Project: I5719B – U5800 Design Build

Subject: Hydraulics CP4B Meeting - Minutes

Date: Wednesday, April 15, 2026

**STREAM SL
SITE 13**

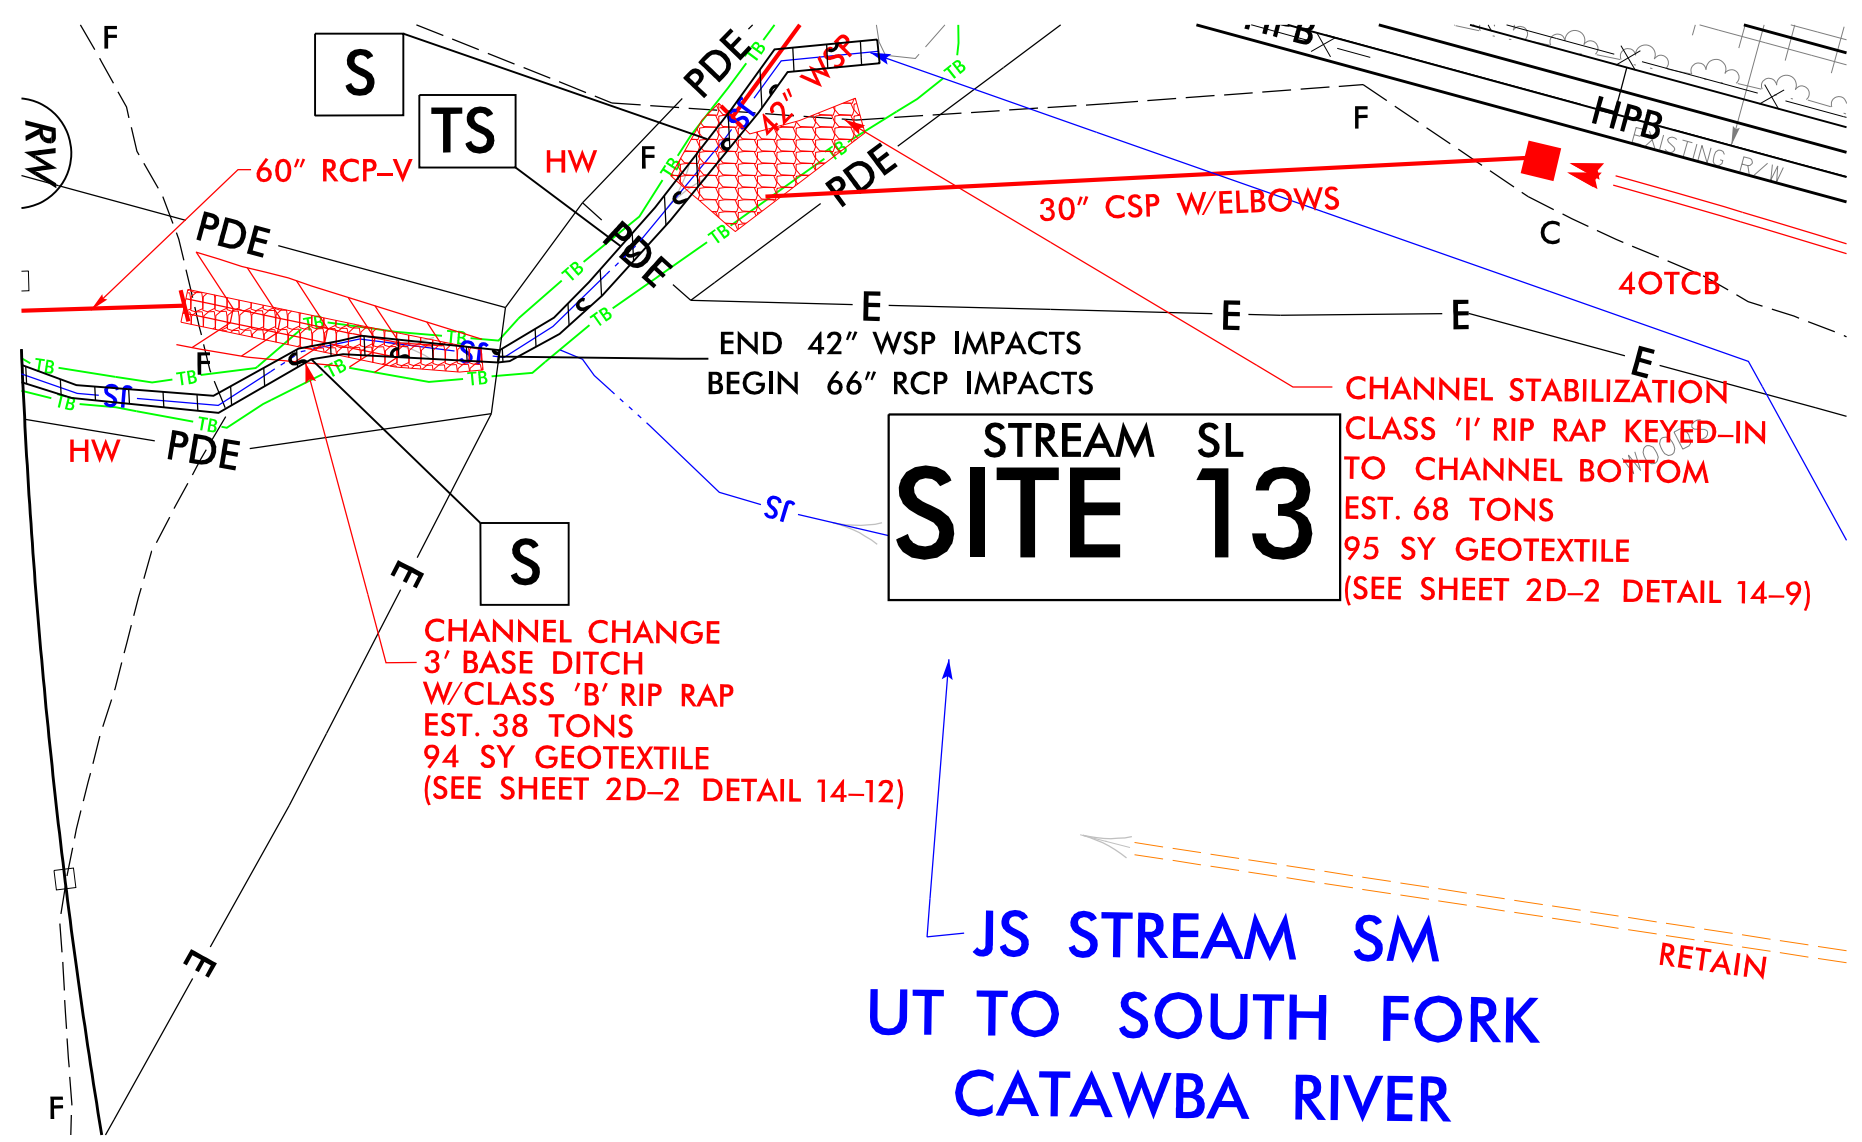
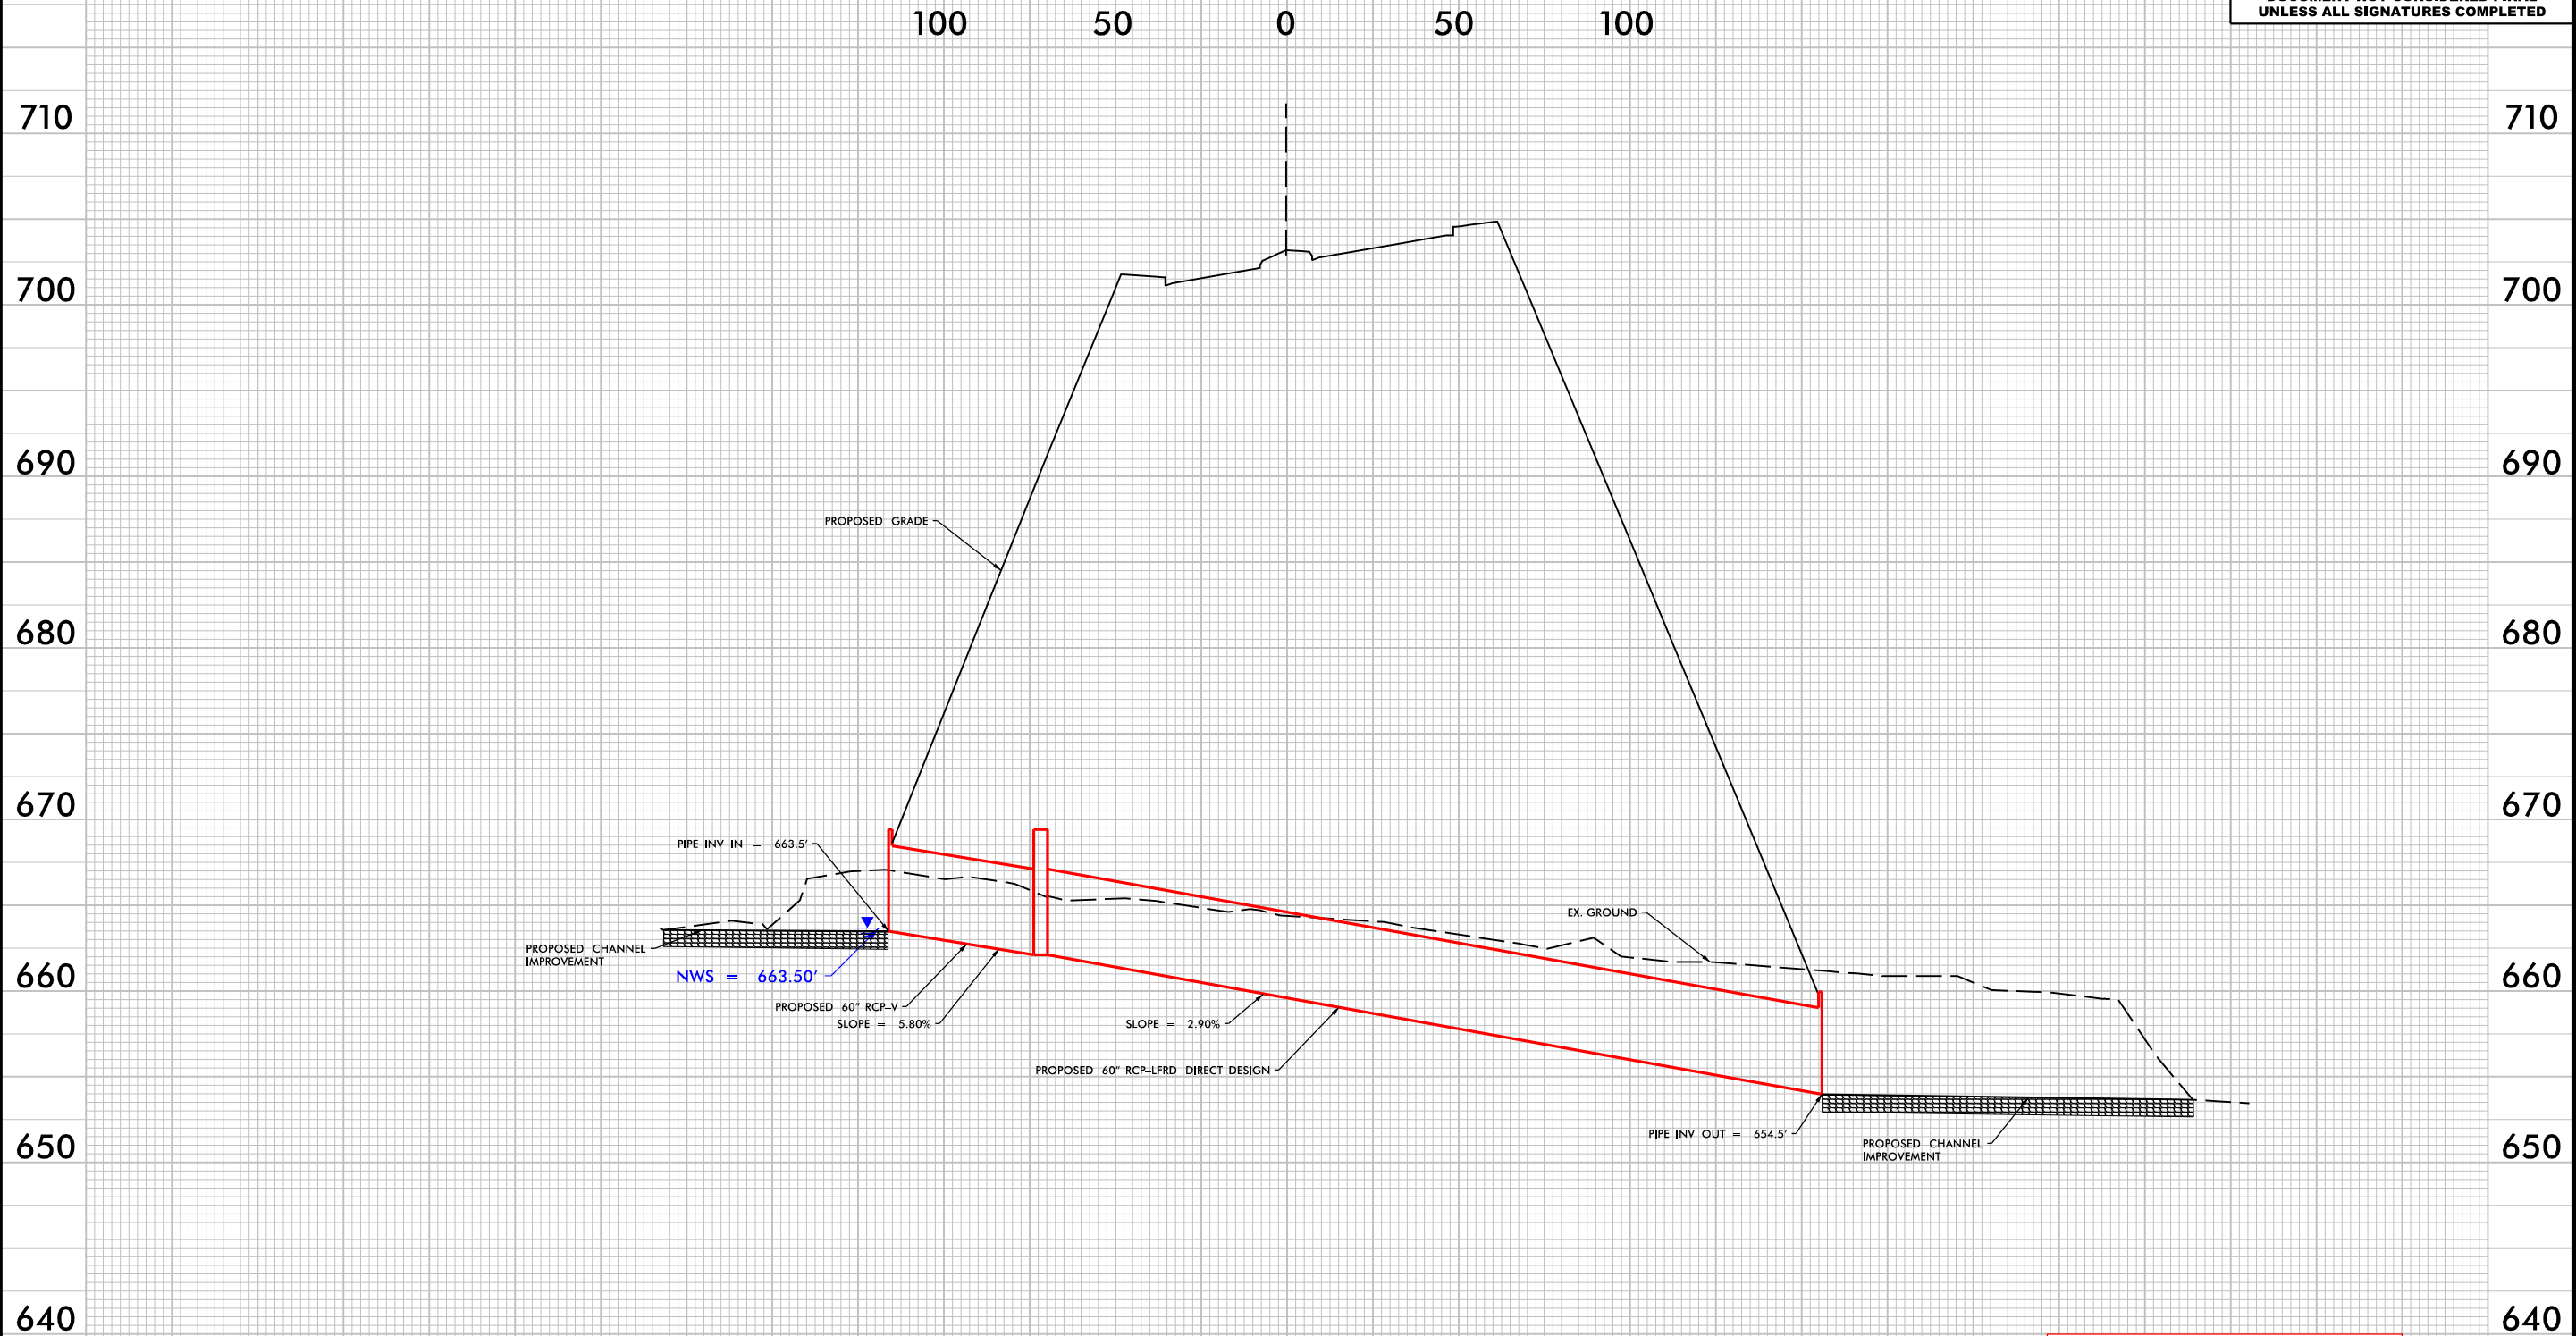
- Showing Rip Rap keyed into the bottom of the stream
- Stream SL – UT to South Fork Catawba River
  - Covering over the stream with new ramp
  - Existing 60" RCP

- Retaining the existing 60" and extending on both ends with a JB
    - Existing pipe is not buried so not showing the extensions to be buried
    - Pipe slope = 1.6%,  $Vel_{10} = 15+$  fps

- If buried, need to discuss sills
  - Upstream
    - Steep Rip Rap lined ditch upstream.
      - Approximately 300' from culvert inlet to the tie in point of Stream SL

- Downstream
    - Showing Rip Rap keyed into the bottom of the stream approximately 15 ft downstream
- Dave McHenry - What is the target discharge for the 60" pipe. The 25 year storm then takes part of the flow to the system to the 84". Dave asked what the flow is at the dam. Division may be looking at the undersized pipes downstream of the culvert. Streams are steep and carrying a lot of water.

- Crystal Amschler – The hydrology of the downstream end will not be impacted as it maintains flow up to the 25-year storm. Diverts the high flow above the 25 year storm.

- Crystal – SL relocation – segment will be a full lost since it is in ditch feature. Stream conditions need to be met. Width, etc. Need a detail for the stream feature and where banks will be. Aquatic passage may be an issue on this one with the new design. Is it currently passing fish. Flatter side of the slope of channels on the project. Bill shared the stream form information. 1 for macrobenthos 0 for fish, crayfish and mussels for SL. Dave says no fish so not worried about passage. Crystal has issues with no passage. How to deal with the upstream reach? Doesn't meet the conditions. No clear answer to address the issue on this one at this time for SL. Continue discussion later and provide direction later. Potential to mitigate entire upstream reach.

*Action Item: Follow up with Crystal via email on Stream SL. Based on the outcome of Stream SL and potential for aquatic passage in to the rip rap lined ditch, need to determine if the 84" pipe needs to be buried with sills.*

*Based on our discussion, the pipe that SL currently flows through would support aquatic passage, but the new design would not. Based on this, I don't see how we can avoid calling any remaining undisturbed features above the proposed pipe a loss due to the change in aquatic passage potential through this system. As such, DOT should provide a mitigation proposal for these waters when a permit application is submitted. DOT should also provide SAM forms and any other pertinent information to justify the mitigation proposal.*

STREAM SBS
SITE 16

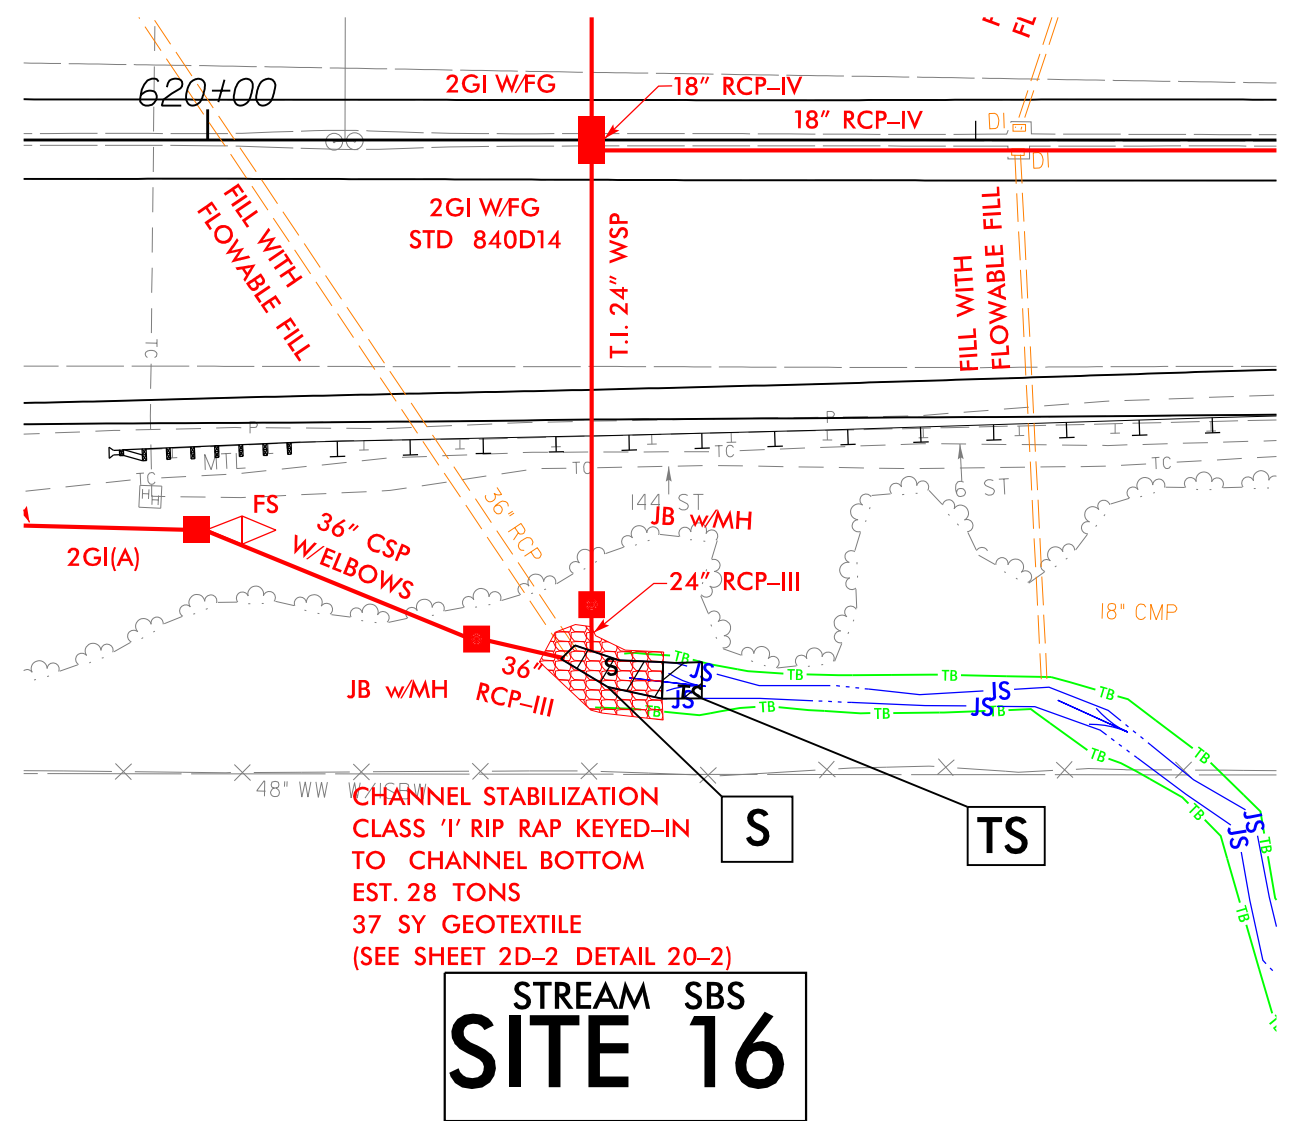
- Mill & fill operation along mainline to begin bridge and replacing guardrail
- Catawba River bridge is outside of construction limits
- Stream SBS – UT to Catawba River

- JS starts at the outlet of the existing 36" RCP
- Replacing with a 24" WSP and 30" CSP
- Showing rip rap in bed of stream for approximately 30'
- Buffers will follow the full pond level of Lake Wylie vs following the stream. Approximate elevation 570.0
- Existing outfall at -L- STA 627+00 RT carried back station at Lane's request per constructability concerns in Catawba River floodplain
